CITY OF MERCER ISLAND

September 14, 2021

RE: Request for Information #1 for File No. SUB21-002 – Angiuli Pacific Res Trust Short Subdivision
4001 West Mercer Way, Mercer Island, WA 98040; King County Tax Parcel # 362350-0365

4001 WEST MERCER WAY SHORT PLAT
TOPOGRAPHIC MAP

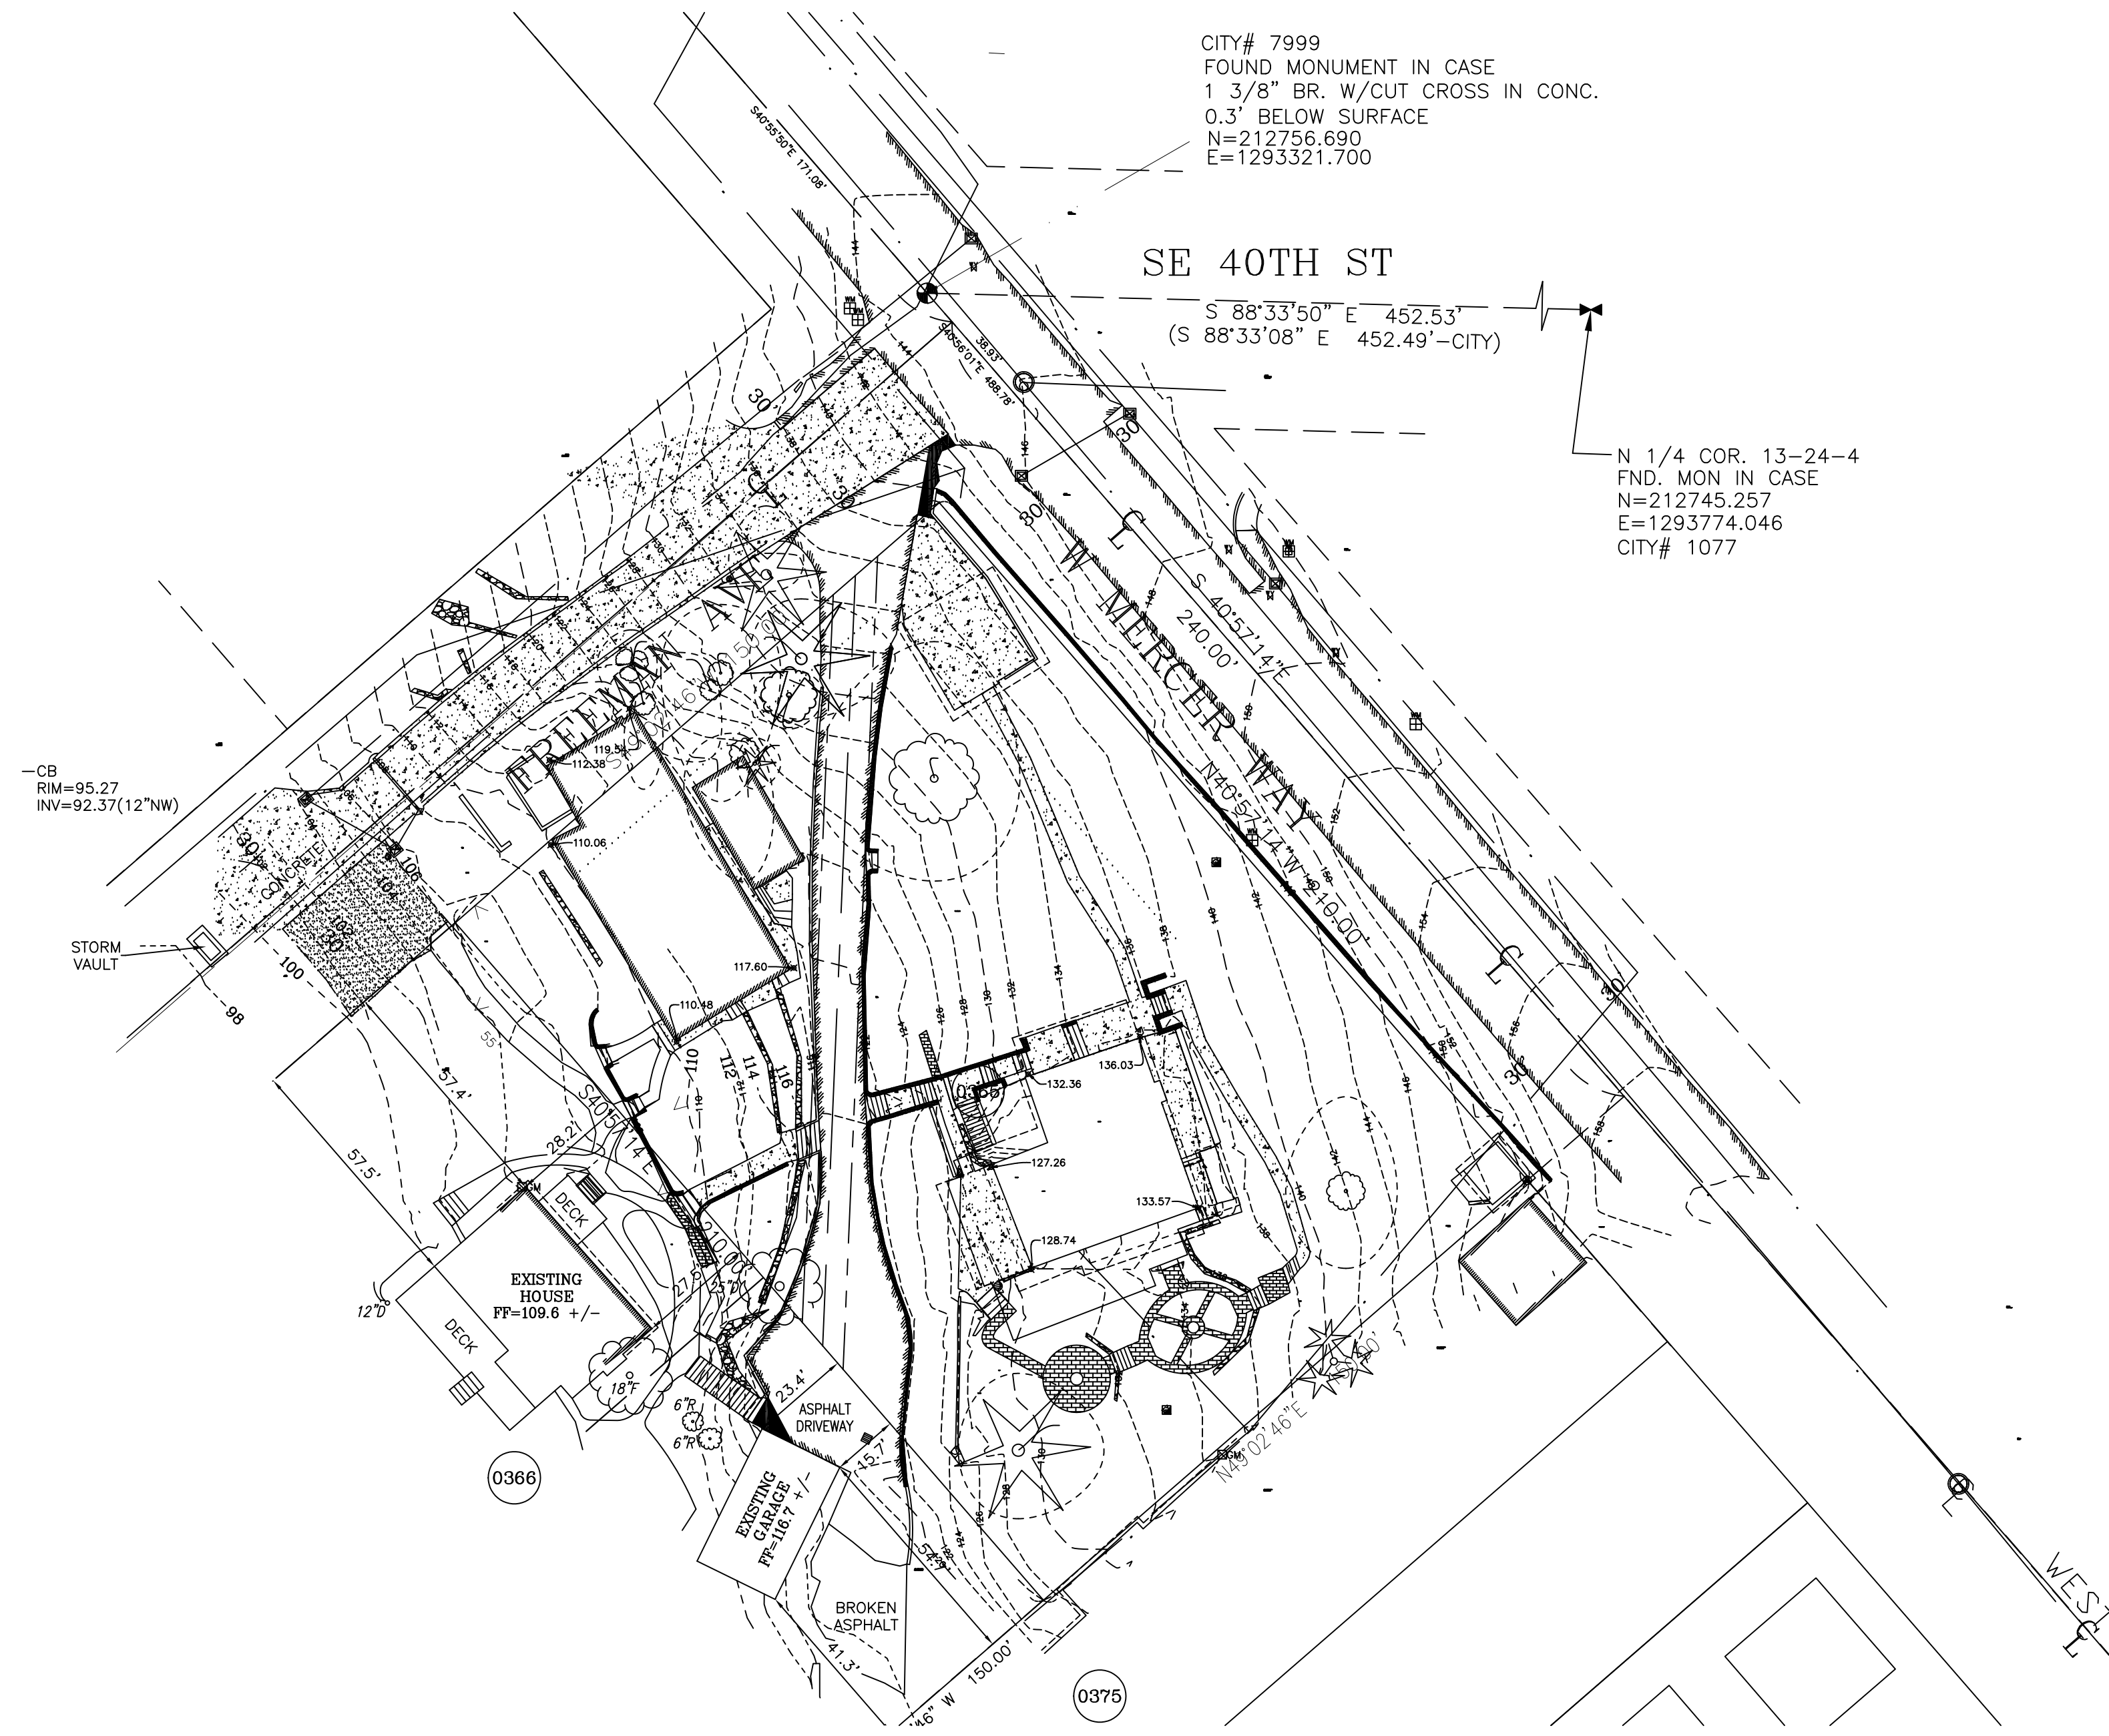
- d. Topographic map: for any existing buildings, the map shall show the finished floor elevations of each floor of the building.
 - e. Please note lot area and net lot area. Net lot area is the area contained within the established boundaries of a lot, less any area used for public or private vehicular access easements, excluding that portion of the easement used for a driveway access to the encumbered lot. The minimum **net lot area** for the R-15 zone is 15,000 square feet. For Lot A, the portion of the access easement used to access the future house on Lot A can be a maximum of 342sf since the current proposed lot area for Lot A is 15,342sf. When measuring the proposed shared access easement area on Lot A using the provided scale it came out to ~885sf.

Figure 21. Tree table.

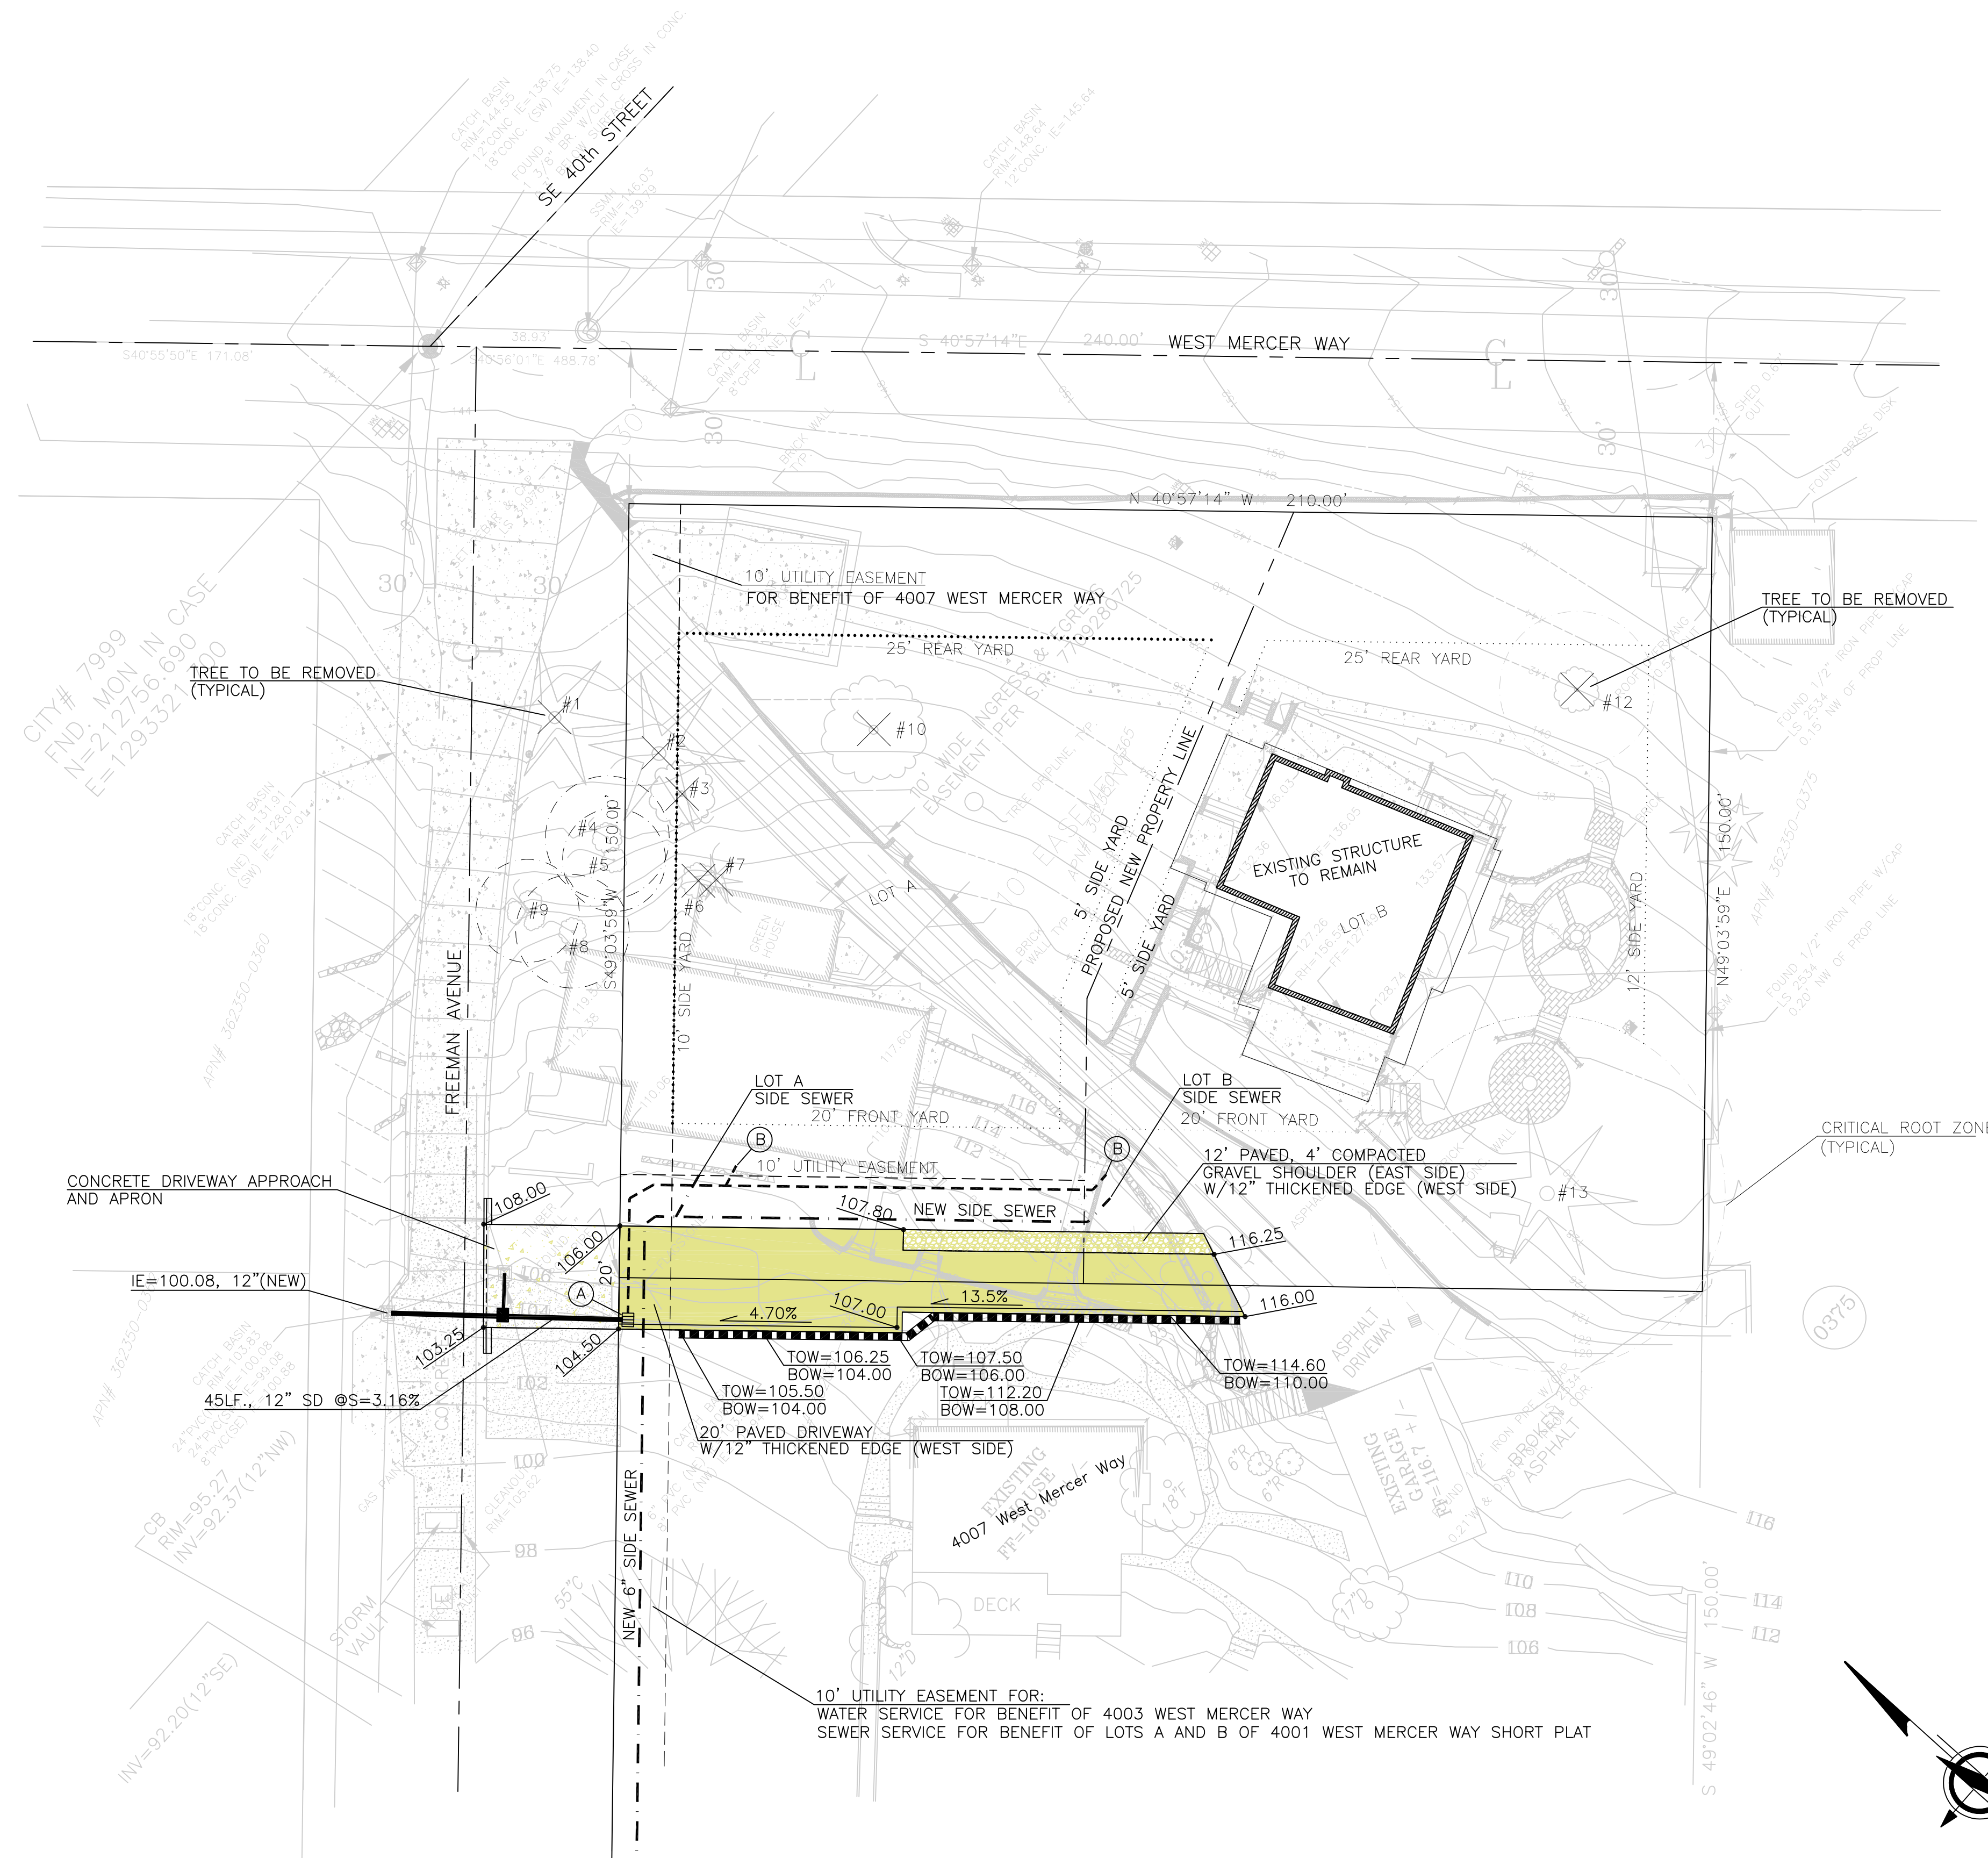
- 13. Trees 1-8 are not on site but in the right of way. Update the "Number of large regulated trees on site" line. As you stated trees 11 and 12 do not need to be included. Update this form to confirm you are retaining at least 30% of the regulated trees on site. This calculation is for this one lot as it currently stands, not the proposed two lots. This means the minimum 30% of trees could be on one lot. Trees outside shown development need to be retained. Currently your proposal is below this requirement and will not be approved per MI19.10.060.A.2.a. https://www.mercerisland.gov/sites/default/files/fileattachments/community_planning_amp_development/page/21988/mercerislandtreeinventory.pdf

- 14. Tree #10 is exceptional and must be protected at its 28' tree protection zone. Unless air excavation or other noninvasive root analysis provides evidence that development can occur closer. Show building pad outside this limit of allowable disturbance or dripline. Or the tree will need justification that the tree can be removed under MI19.10.060.A.3.
